**Ann Machado - 48 Hancock Street - Permit #2015-00033**

**From:** Ann Machado  
**To:** Philip DiPierro  
**Date:** 2/4/2015 3:50 PM  
**Subject:** 48 Hancock Street - Permit #2015-00033  
**CC:** Caitlin Cameron

I have finished my initial zoning review. This is what I need:

EXISTING CONDITIONS PLAN
 48 AND 50 HANCOCK STREET
 PORTLAND, MAINE

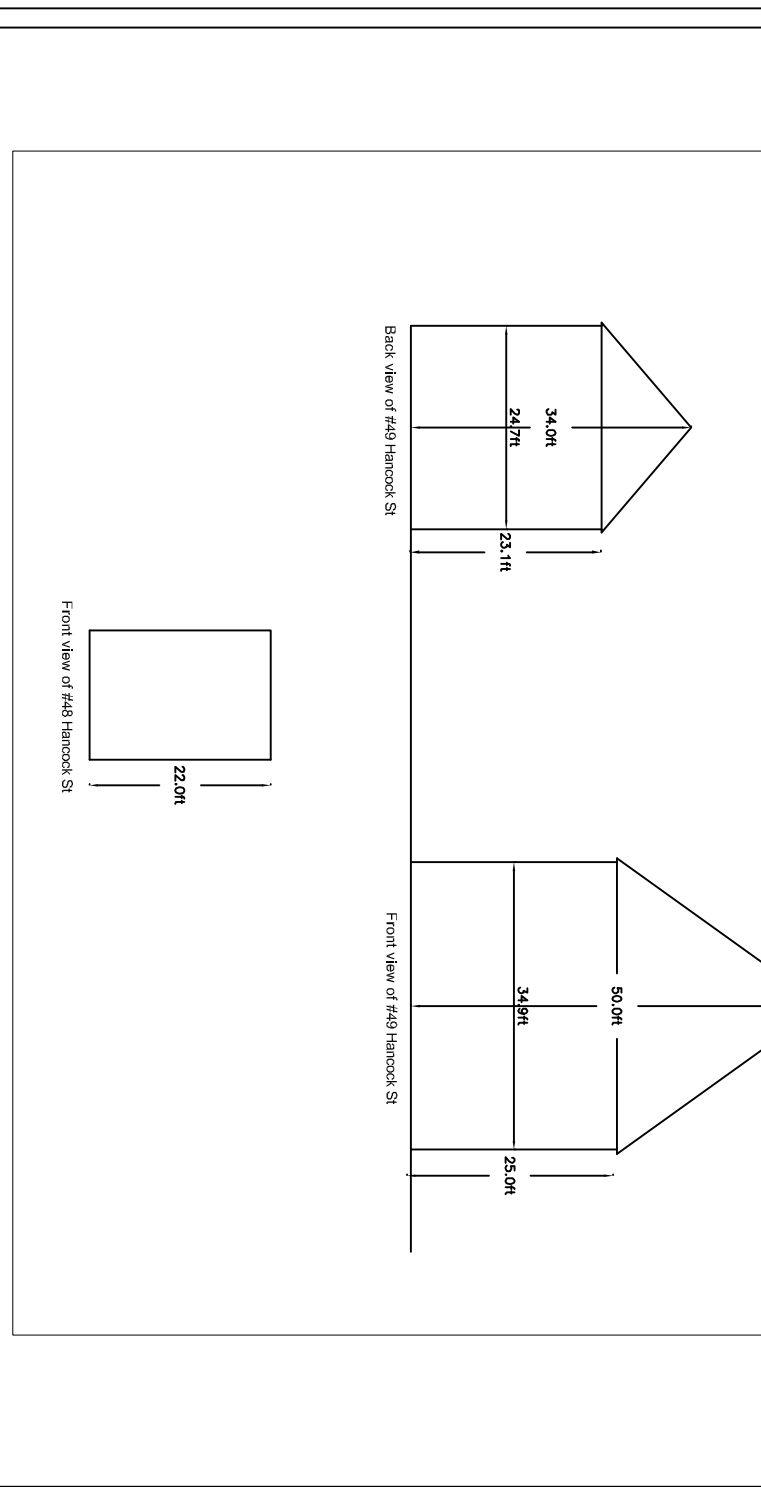
1. There is no scale on the site plan. What is the impervious surface area?
2. On the boundary survey, the two corners of the lot on the right front and rear are not indicated. I can't tell exactly where the property lines are. Also the dimensions of the lot are unclear.
3. What is the use of the tower? It is above the 45' maximum height.
4. With the elevations, there is no North elevation. Also it looks like there is a railing around part of the top floor but on the west elevation, it looks like more solid. What is this?
5. As far as the two required parking spaces, the lot was legally nonconforming before as to parking spaces. It is a new structure but the unless if is vacant for over a year the nonconformity of parking spaces would remain. They are set with one parking space but they can't use any spaces across the street at 49 Hancock.
